DECISION DELEGATED TO HEAD OF PLANNING

Application No: H16-0191-25 **Applicant:** Mr T Mahmood
Proposal: Replacement of Side Windows and Front Door
Location: 38 Spring Gardens Spalding Lincolnshire
Terminal Date: 26th May 2025

Amended Key Plan for replacement windows & front door at 38 Spring Gardens, Spalding, Lincs, PE11 2XL.

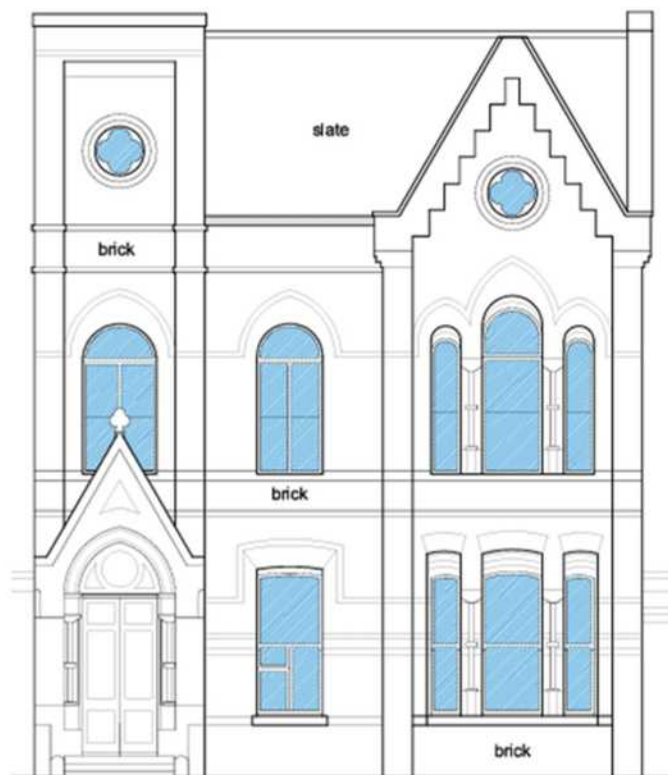
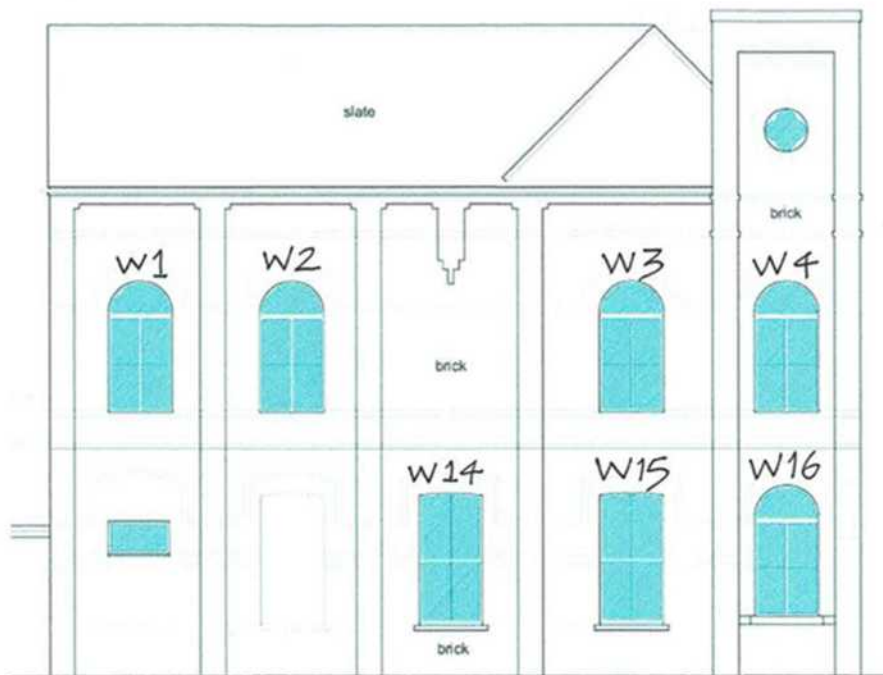
With the above in mind, the Local Planning Authority considers the proposal to represent a form of harm. That harm is identified as 'Less than substantial harm' and is borne of the fact that the proposed windows are not of an identical nature to the existing in terms of frame style and glazing format. Nevertheless, the styles remain ornate and fitted to the vaulted openings.

As less than substantial harm is identified, clear and convincing justification is required and in this instance, in achieving the consented use, which is considered to be the optimum viable use for this currently disused site, typically opening windows allowing ventilation and not harming interior usable space is considered to be convincing, particularly as the amendment secured ensures that the

frontage elevation windows - which are by far the most significant architecturally on site.

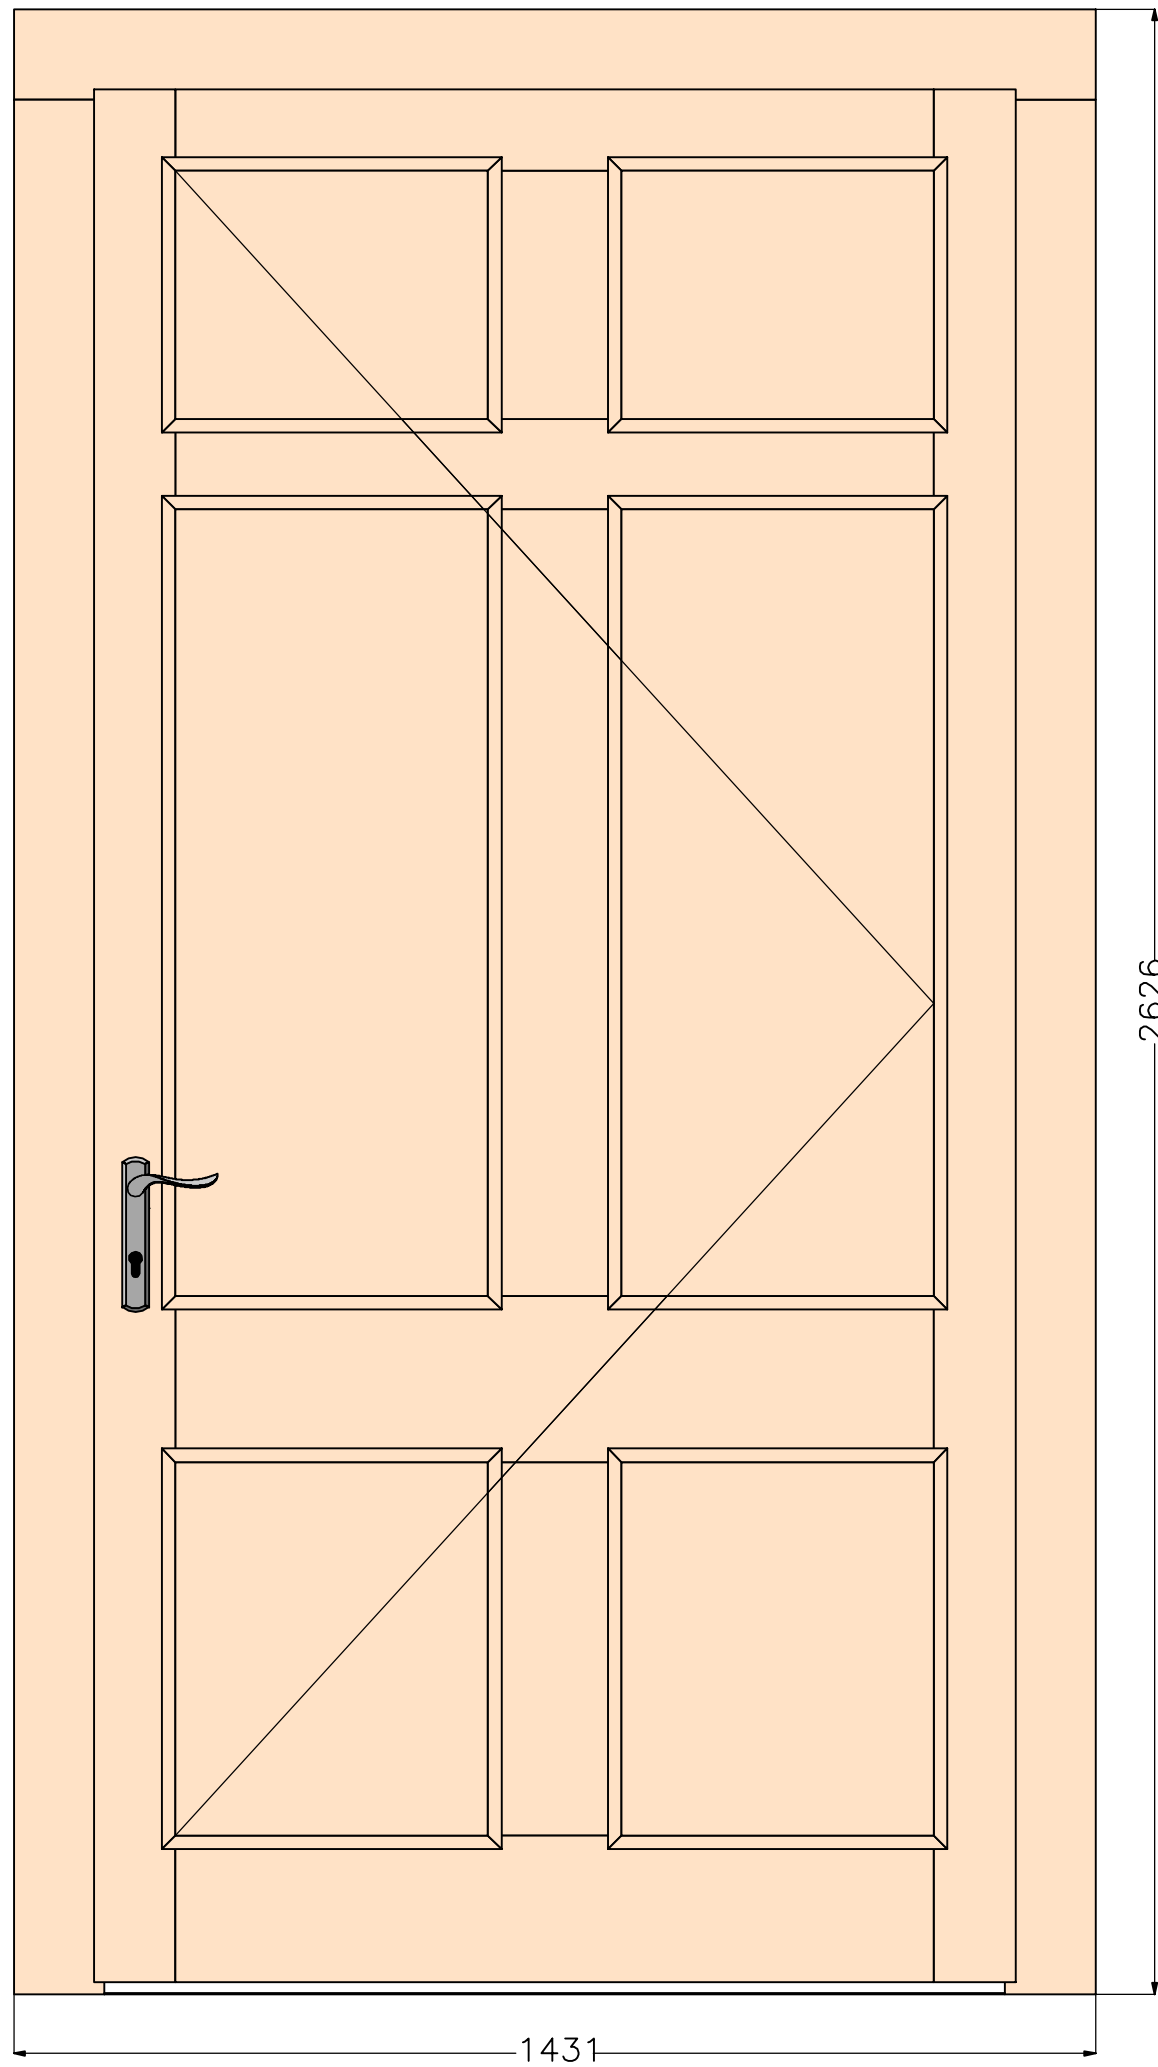
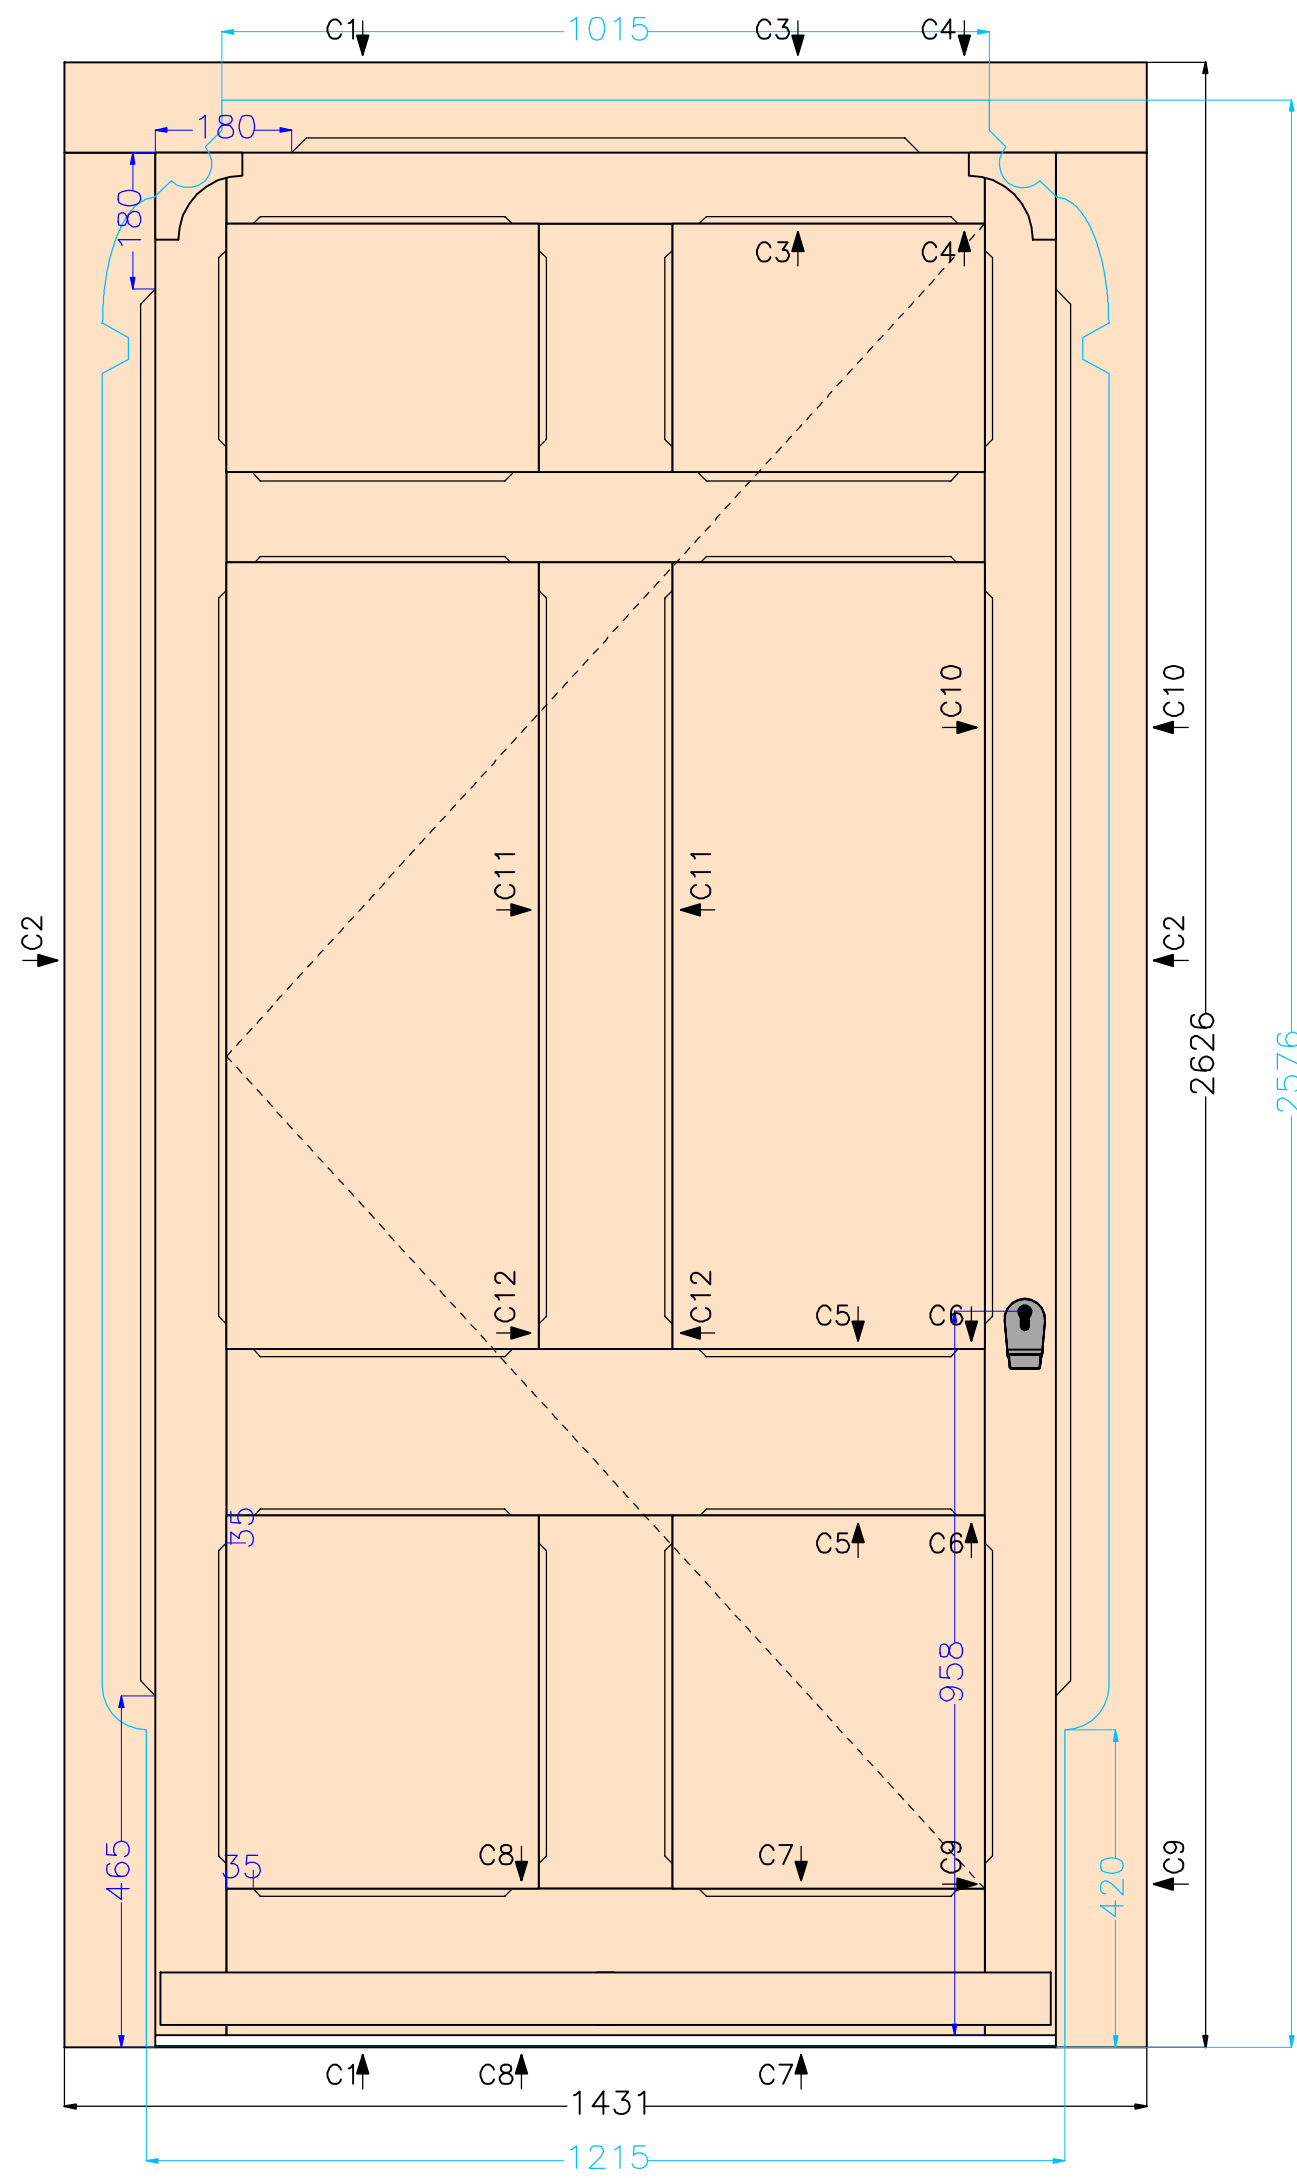
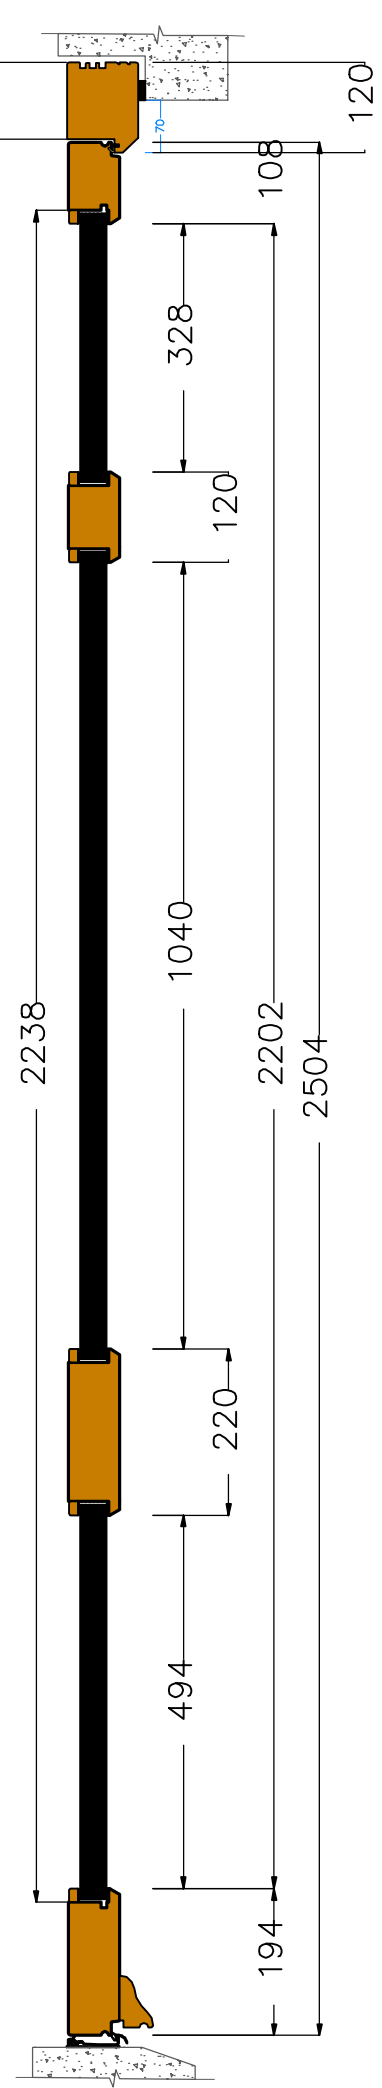
The proposed door is also not 100% replicative of the existing door. However, the extant is heavily damaged, well beyond repair. The proposed replacement does seek to utilise similar construction, using timber and a style, which whilst slightly simpler, is generally inspired by the on site style and would not appear out of keeping or at odds with the setting.
